~~DRAINAGE LETTER~~

Gunners Ridge Minor Subdivision
12172 Goodson Rd
El Paso County, Colorado

JOB NO. 192027

February 22, 2023

SHEET NO. DR02

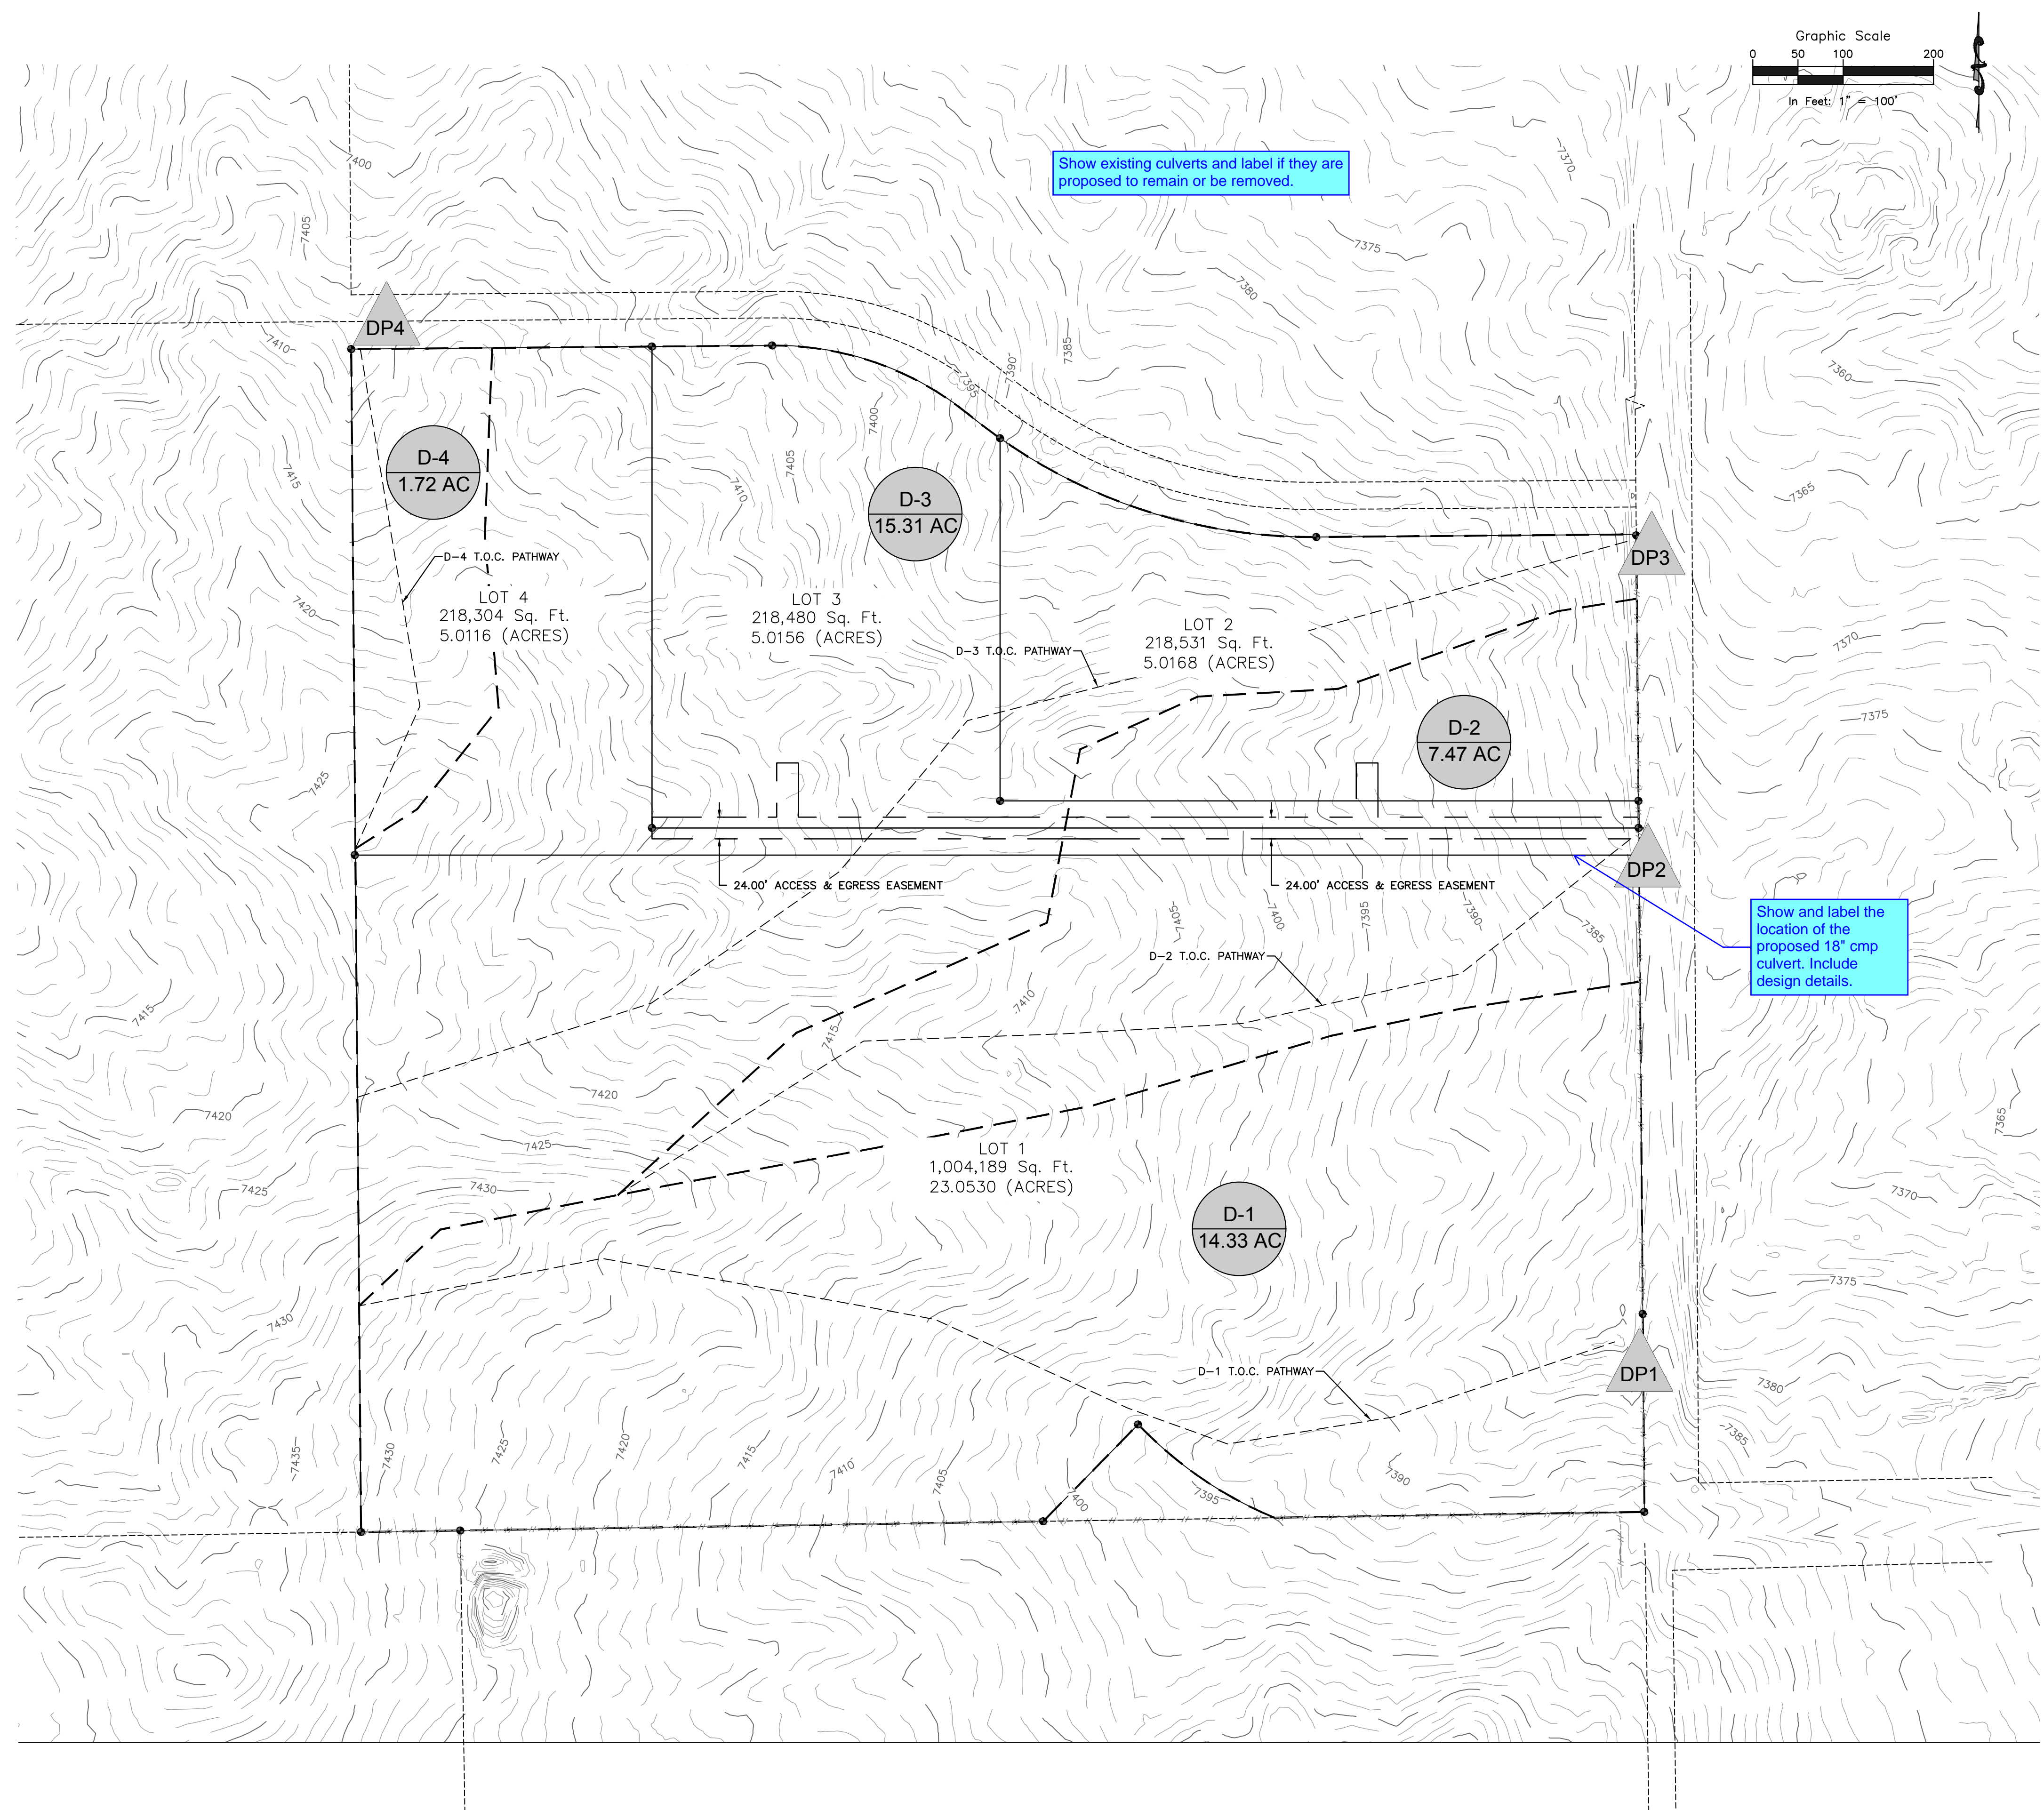
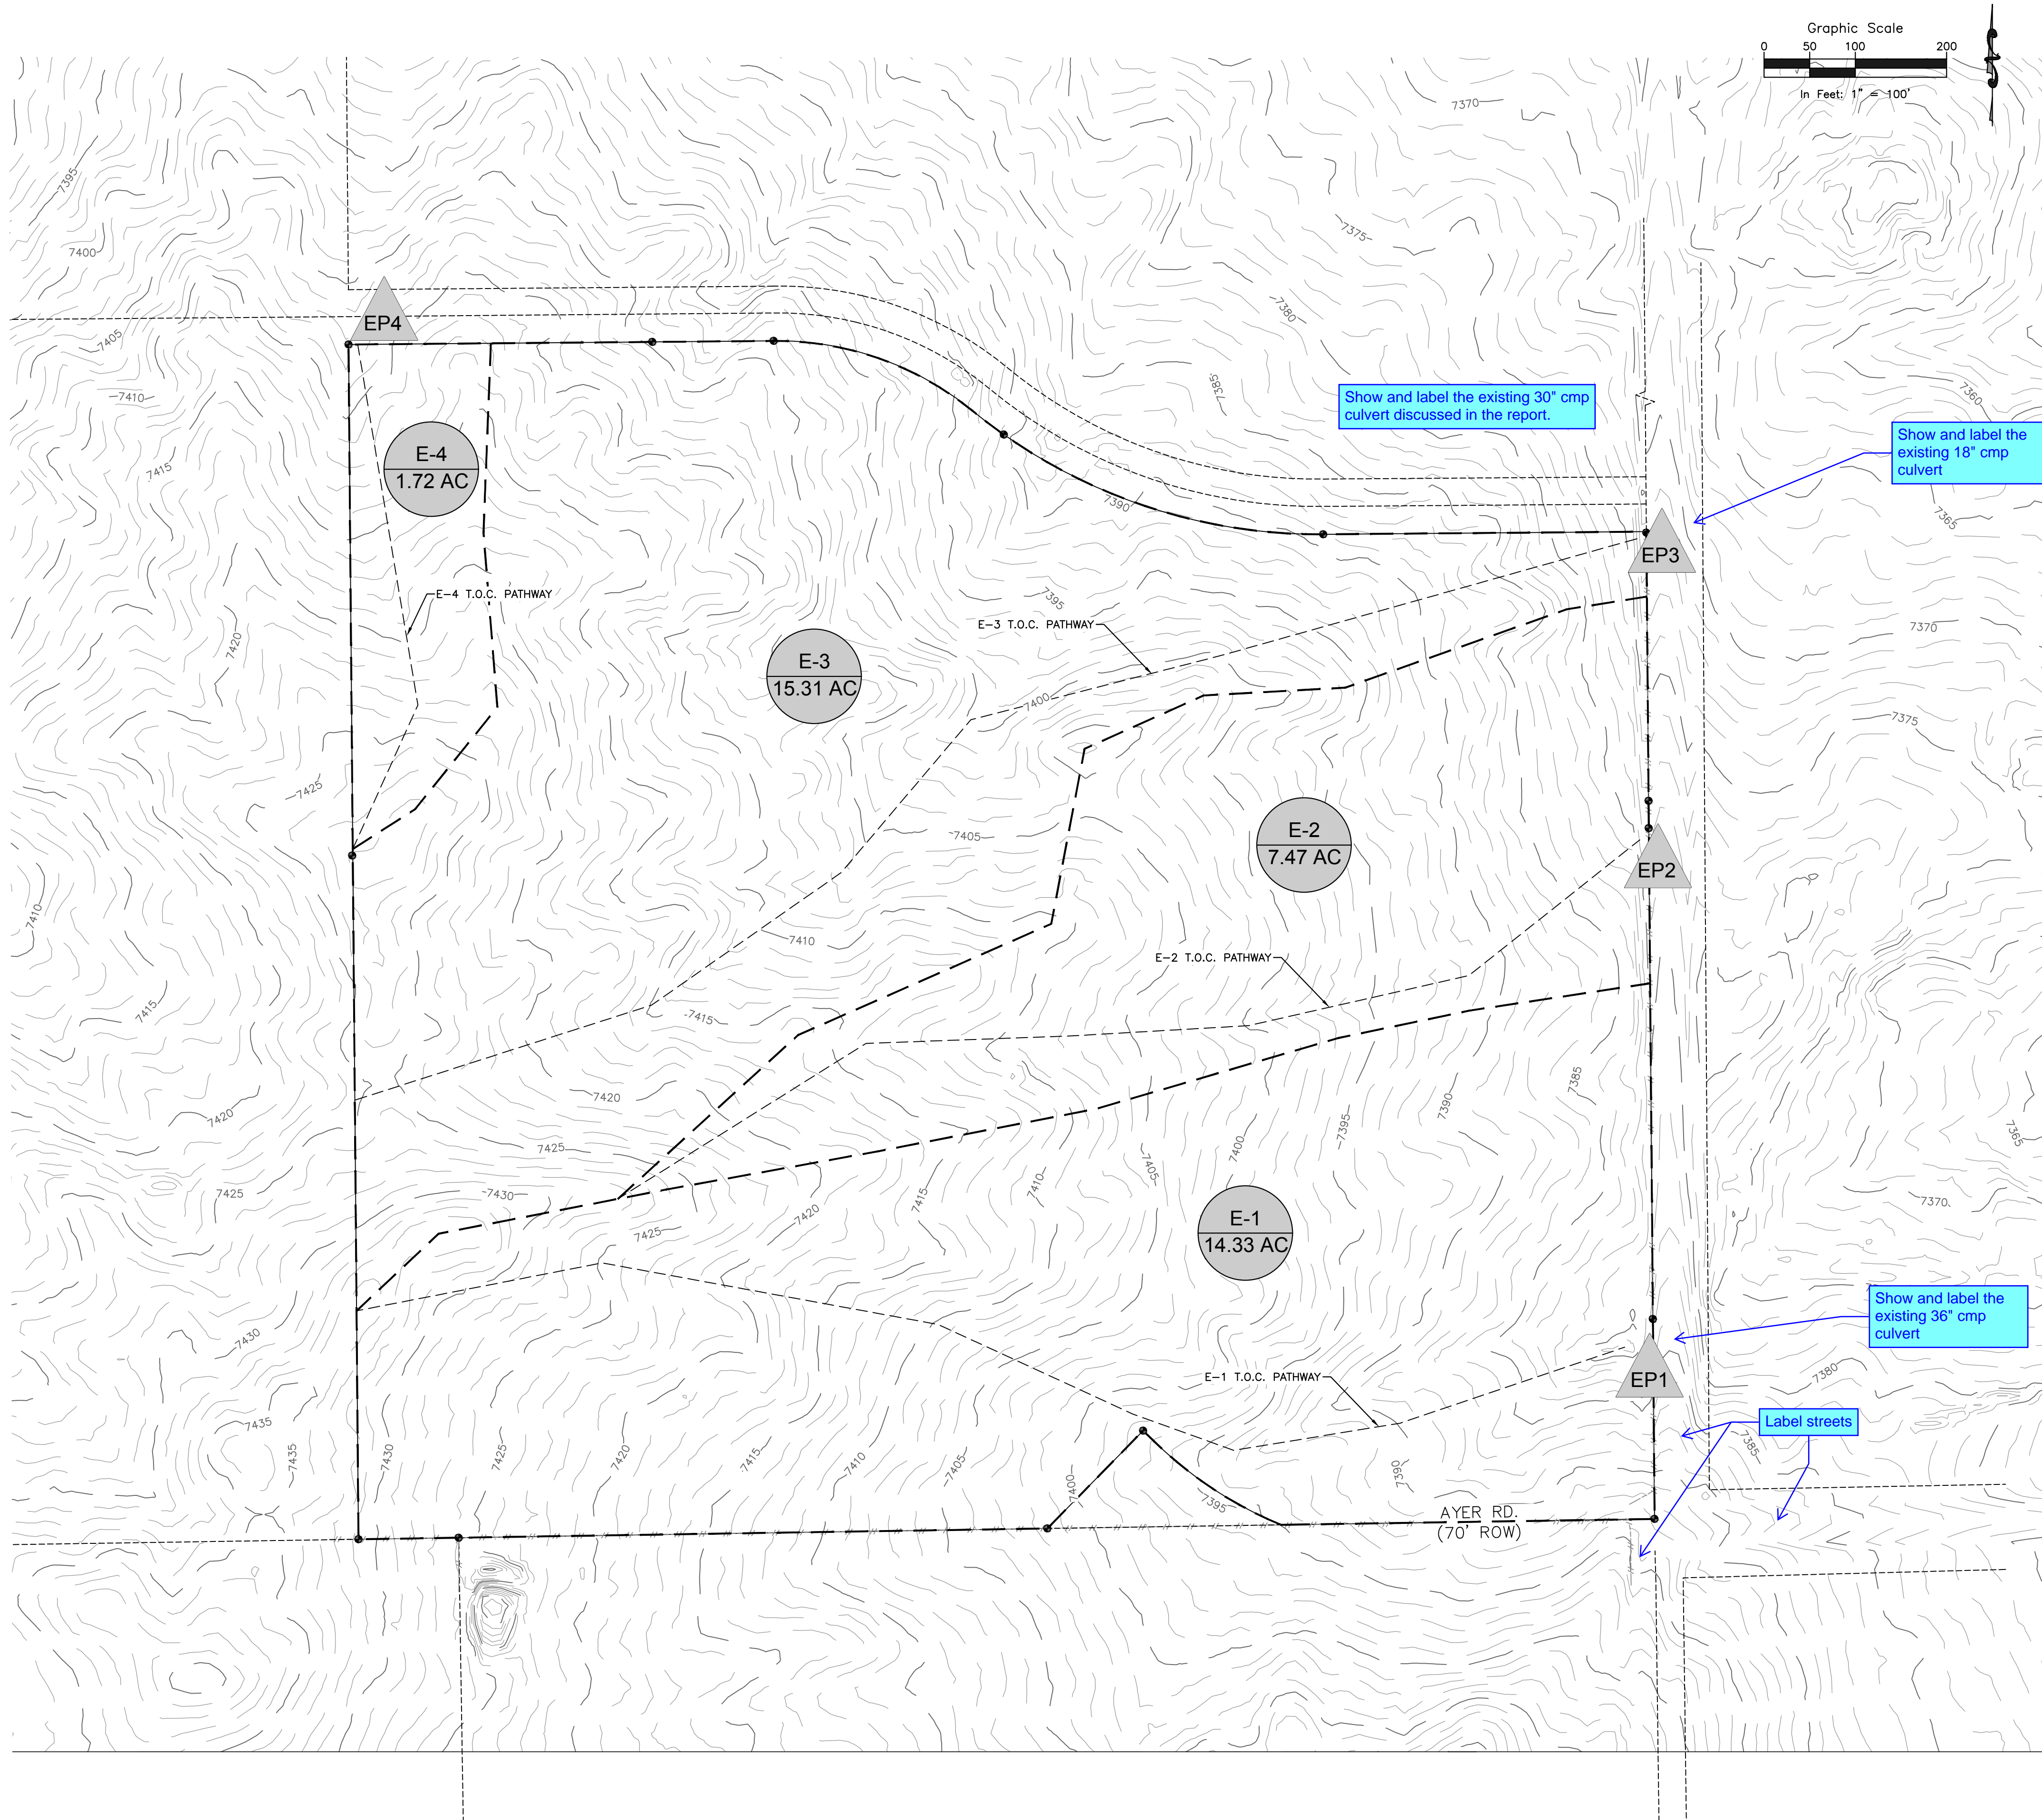
- Discuss existing and proposed hydrologic conditions including approximate flow rates entering and exiting the sub-division. Provide all calculations (hydrologic and hydraulic).
- Discuss if any existing or proposed improvements/facilities are required such as culverts.

Provide the amount of land disturbance from the development. Grading will most likely be done for the driveway, discuss the amount expected and analysis if a culvert is required.

Provide drainage plans for existing and proposed conditions. Maps should be the last pages in the report.

Without a map that shows proposed improvements, it is unknown if WQ treatment is required.
